DEVELOPMENT REVIEW BOARD
SUPPLEMENTAL SUBMITTAL

PROJECT NO. 2020-004475
Application No. SI-2021-00254

SUBMITTAL
DESCRIPTION: Dental office for Pino Periodontics. This submittal includes the responses to the staff comments from the DRB hearing 5-5-21.

RE: Pino Periodontics dental office development at 7413 Holly Ave NE.

A NEW DENTAL OFFICE FOR:  
**PINO PERIODONTICS**  
CURTIS PINO, DDS, MSD  
7413 HOLLY AVENUE, NE  
ALBUQUERQUE, NM

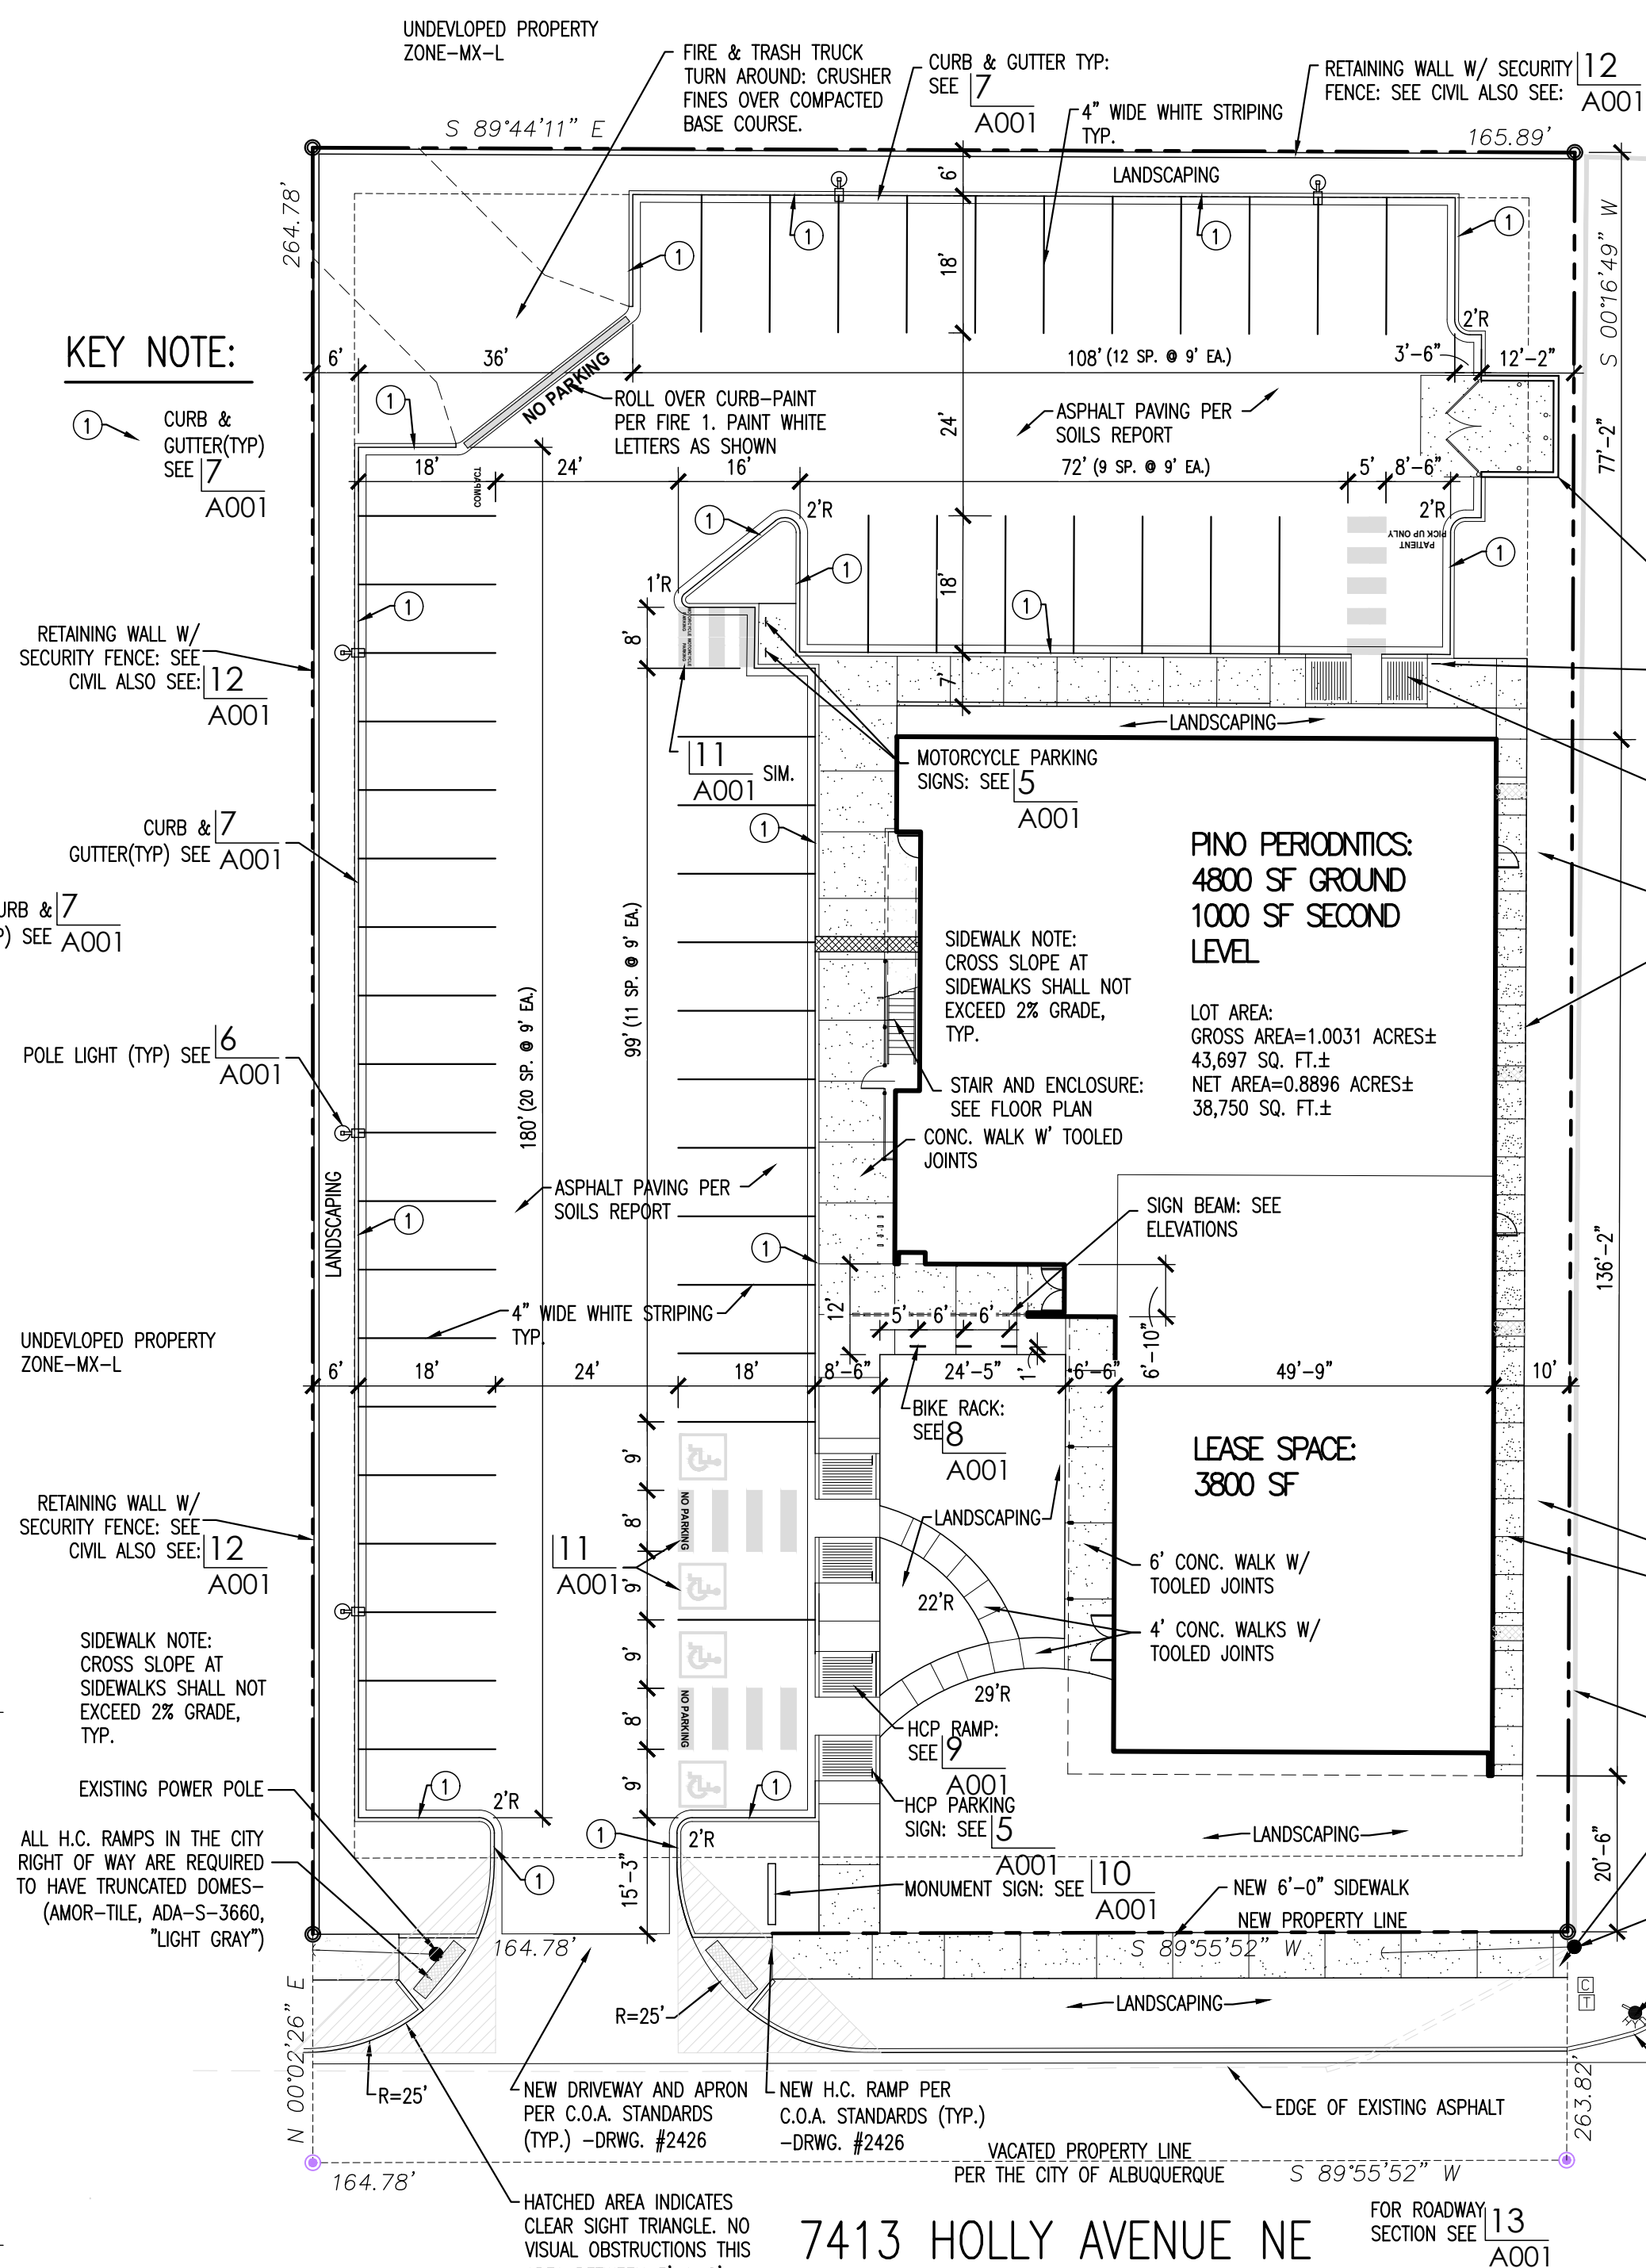
1. **Reference ramp detail to north ramp:** Site plan has been updated with correct key to north ramp.
2. **Provide hcp access from south ramps:** Detail 9/A001 has been revised to indicate there is no curb at south ramp locations.
